# DRB CASE ACTION LOG (PREL & FINAL)

DRB Application No.: 04DRB-01298 (P&F)

Project # 1003635

Project Name: EASTRIDGE PLAZA

PLAT OF  
LOTS 1-B-1 AND 2-B-1  
EASTRIDGE PLAZA ADDITION

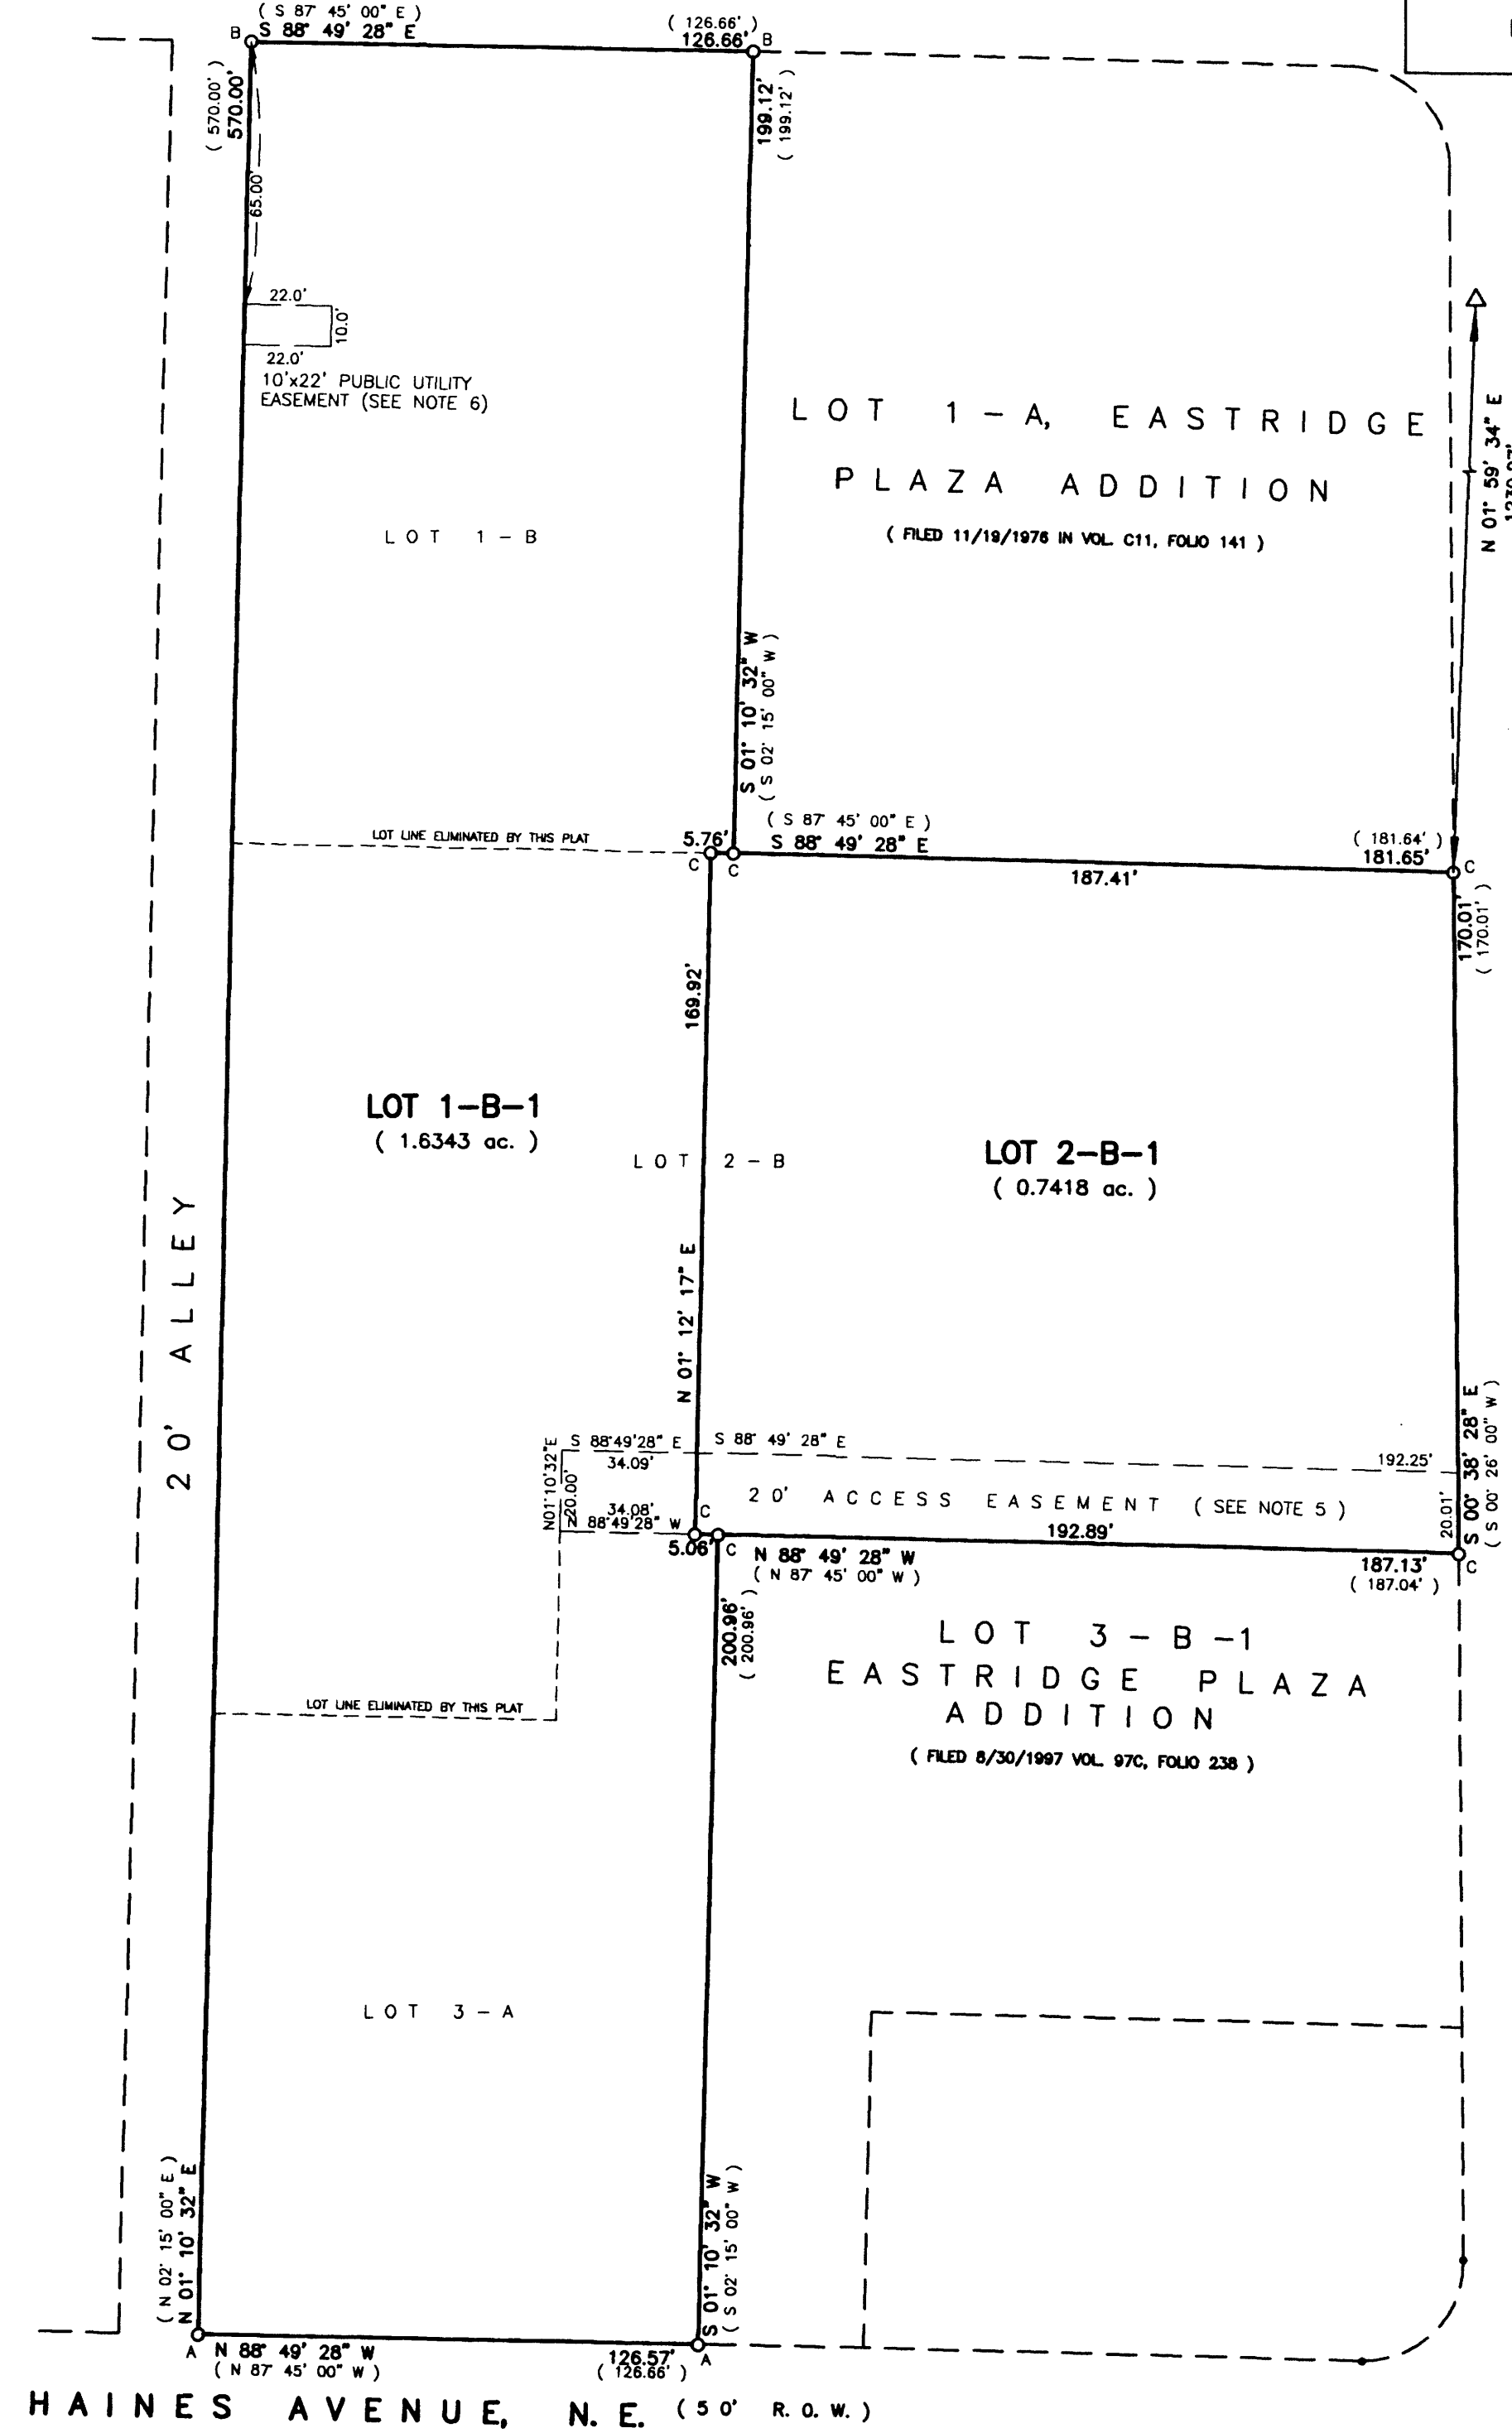
The C2 zone has virtually no building setback requirements unless the property abuts residential uses. In this case, the rear yard abuts an alley across from residential uses. In any case, the 22 foot rear setback shown on the plat satisfies the setback requirements of 11 feet from an alley.
